## Application for a Non-Material Amendment Following a Grant of Planning Permission

First floor extension to front, new front porch, single storey rear extension, first floor extension above garage, new dormers to front and rear. New outbuilding to the rear. Alterations to fenestration.

23/00445/HOUSE

21099-P1450P1-Proposed Elevations

3 ELEVATION  
Proposed Side Elevation SCALE 1: 100

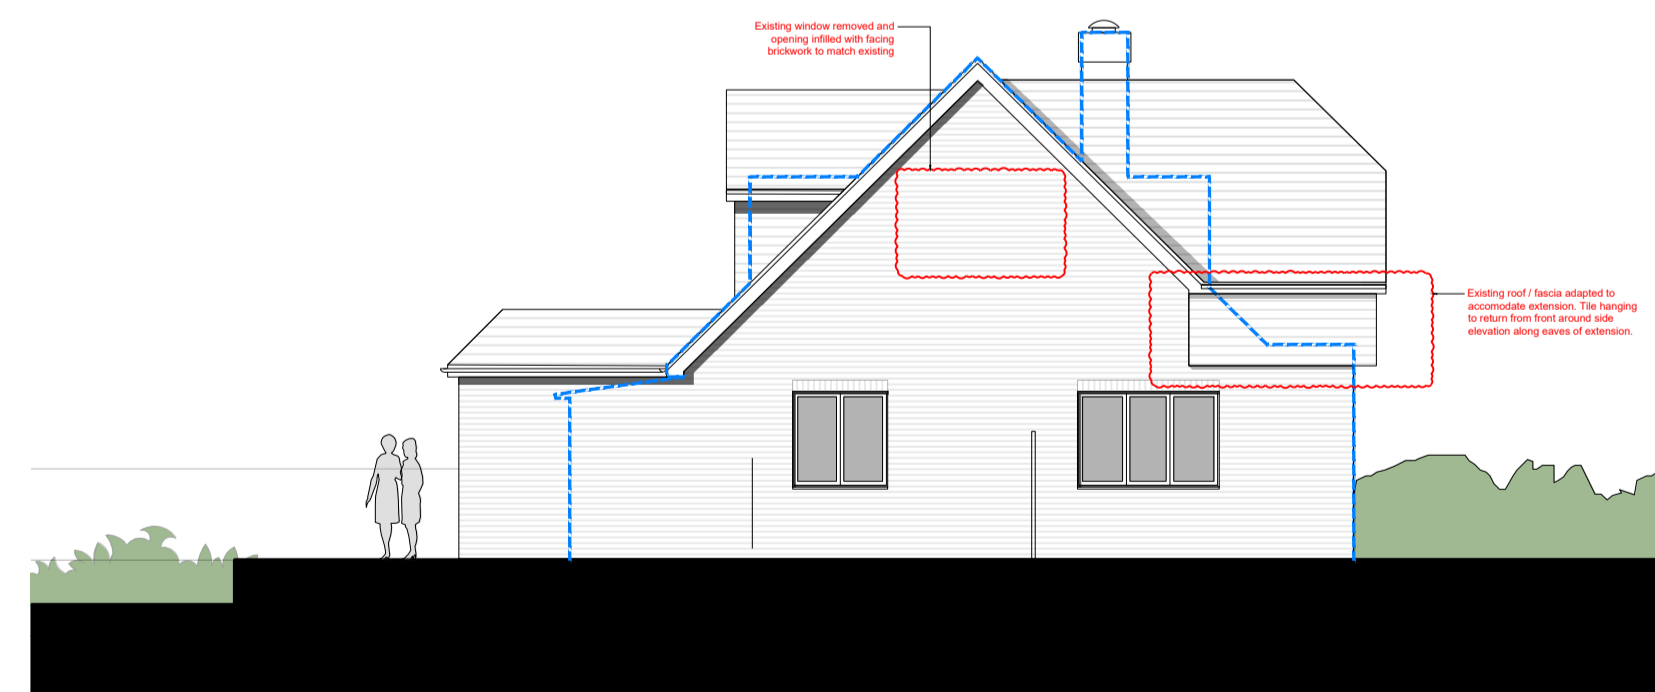
An existing first floor window to the West side elevation is to be removed and the opening infilled with brickwork to match the existing. Following the technical design stage, there is a need for the front portion of the roof at the West side elevation to be slightly adapted where the fascia/bargeboard of the gable meets the fascia of the eaves to the front extension, rather than continuing beyond as shown in the original planning drawings. Following this, the tile hanging to the front extension is now proposed to return around the side elevation and continue along the eaves of the projection.
